DESIGN STATEMENT BY THE CONSULTANT

PROJECT: Trinity Grammar School Renewal Project
Prospect Road, Summer Hill, NSW, 2130

Trinity Grammar School Redevelopment – Modification 5 (SSD-10371-Mod-5)

Source: Arcadia Landscape Architecture, Drawing No. 203, October 2020, Issue C.

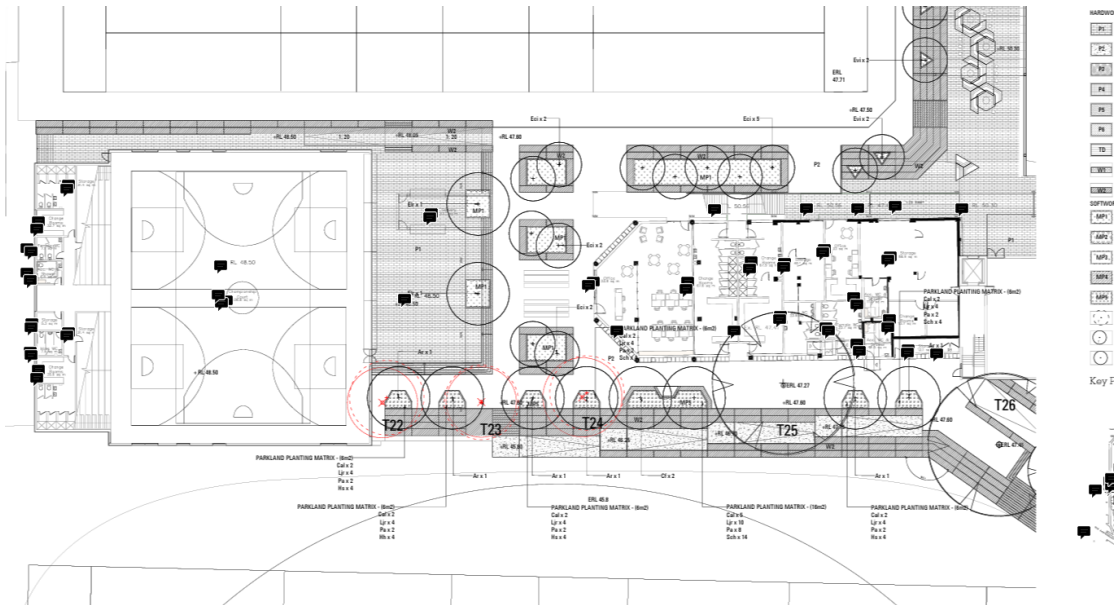
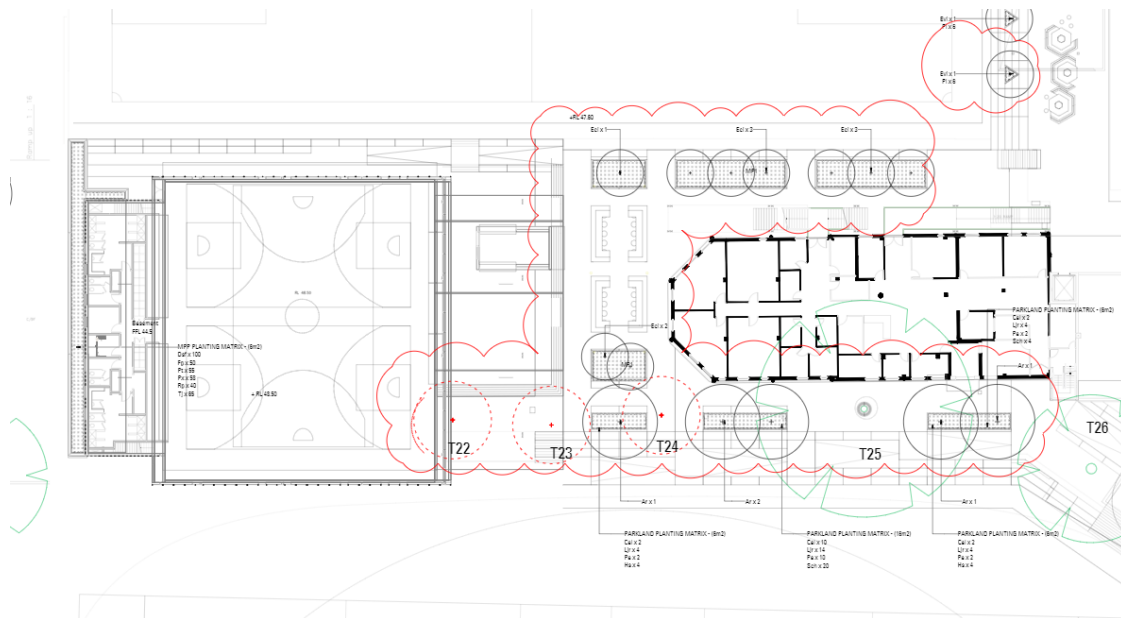
Fixed furniture including bar tables and benches removed from courtyard at user group request to improve the flexibility of this space and allow for adaptable programming

Structural slab constraints extend further towards Oval 1, which compromises the available soil volume to the planter. In response, we have proposed changing 1no. tree from *Agathis robusta* to *Eucalyptus cineria*, which requires significantly less soil. This species is also used within other raised planters in the vicinity so this change maintains a consistent design approach.

Following the architectural change to the fire isolated stairwell, which required the stairwell to extend further east into the landscape, the design of the accessible ramps has been amended to suit. The landscape amendment maintains a useable dimension to the 1:20 ramp, maintains the required maintenance vehicle access around Oval 1, and maintains equal seating amenity to the original submission whilst ensuring the ongoing viability of existing tree no.26, which is to be retained in permeable paving to maximise natural infiltration of rainwater into the root zone.

Source: Arcadia Landscape Architecture, Drawing No. 200, October 2020, Issue C.

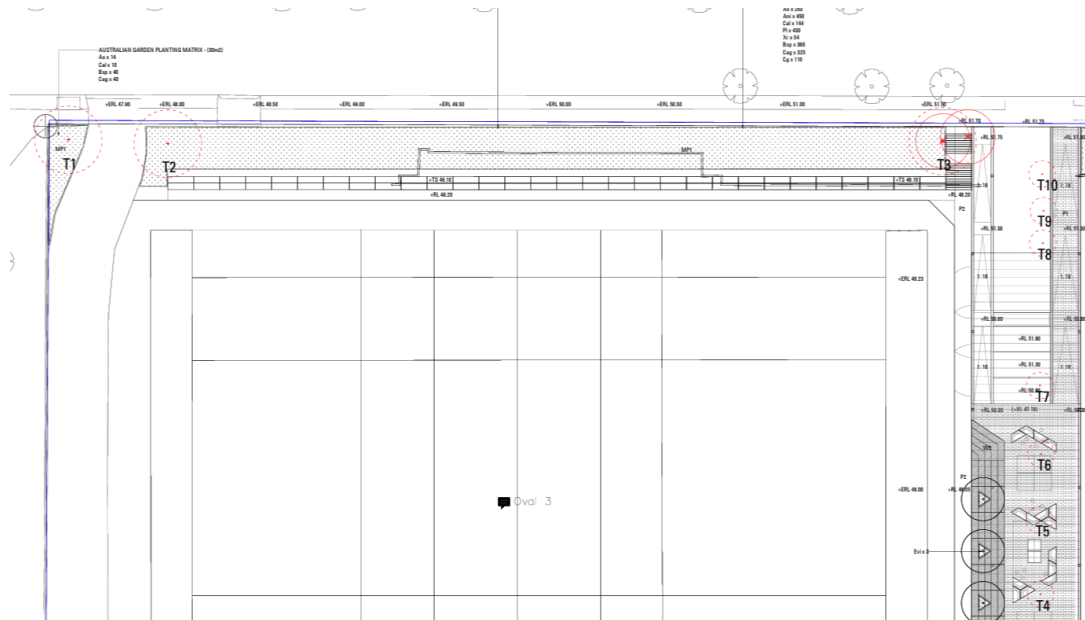
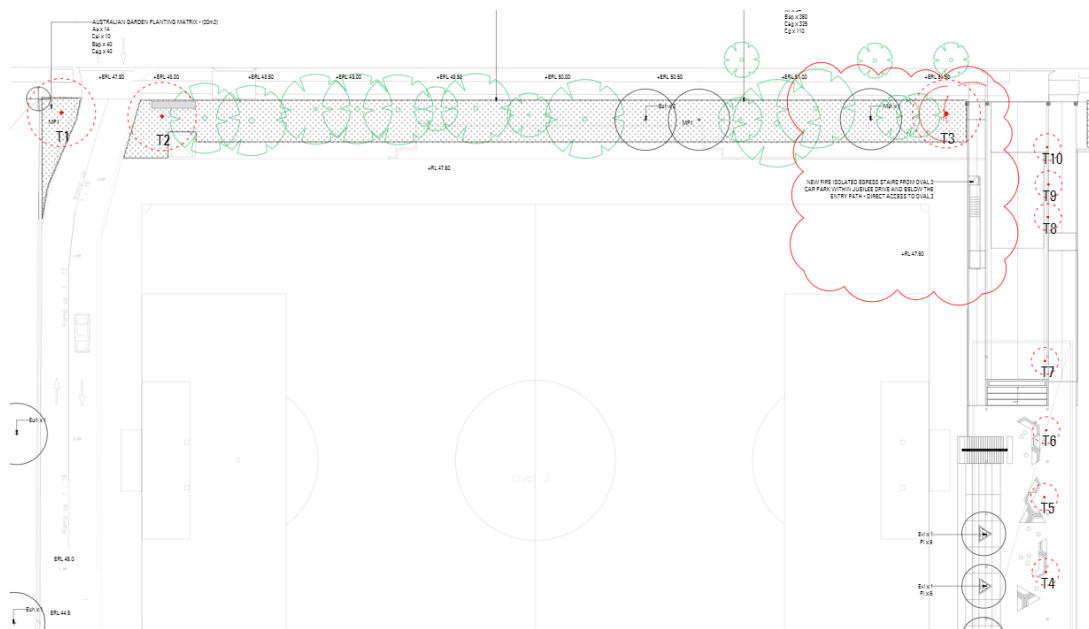
The stair, seating terraces, and 4no. trees to the Jubilee Drive landscape were relocated further east to provide the necessary vertical clearance in the basement beneath for the driveway swept path.

Source: Arcadia Landscape Architecture, Drawing No. 207, October 2020, Issue C.

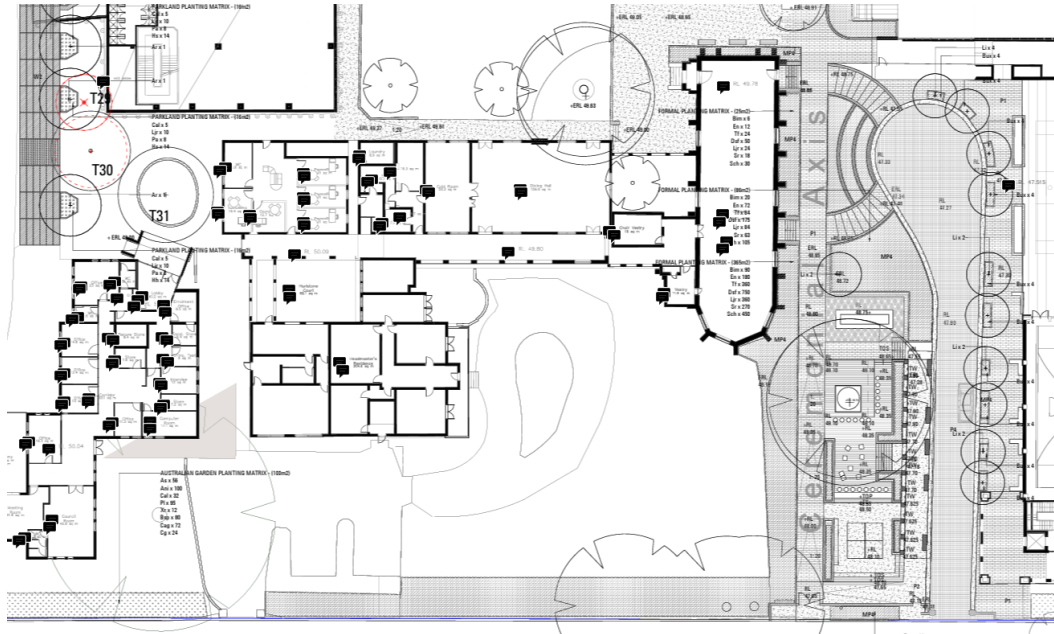
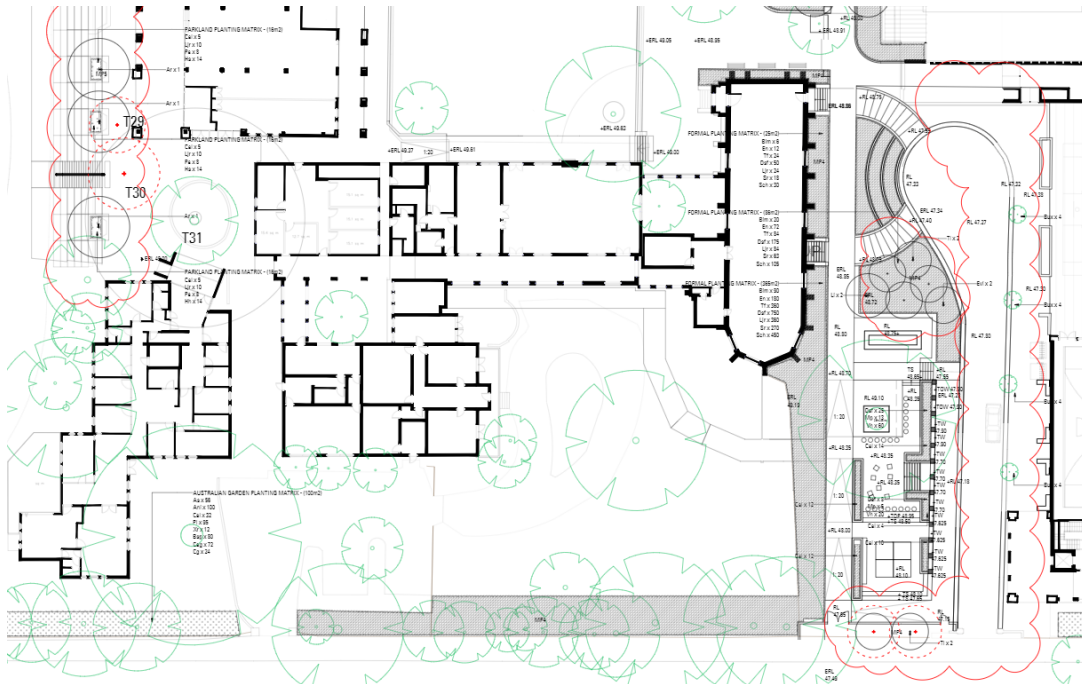
Following discussion with the school stakeholder group the Chapel Drive water feature element has been redesigned as a water wall. In addition, the grove of new trees adjacent the ceremonial axis will now include one additional tree, an Acer palmatum, following a request from the School for a dedicated 'Survivor' tree.
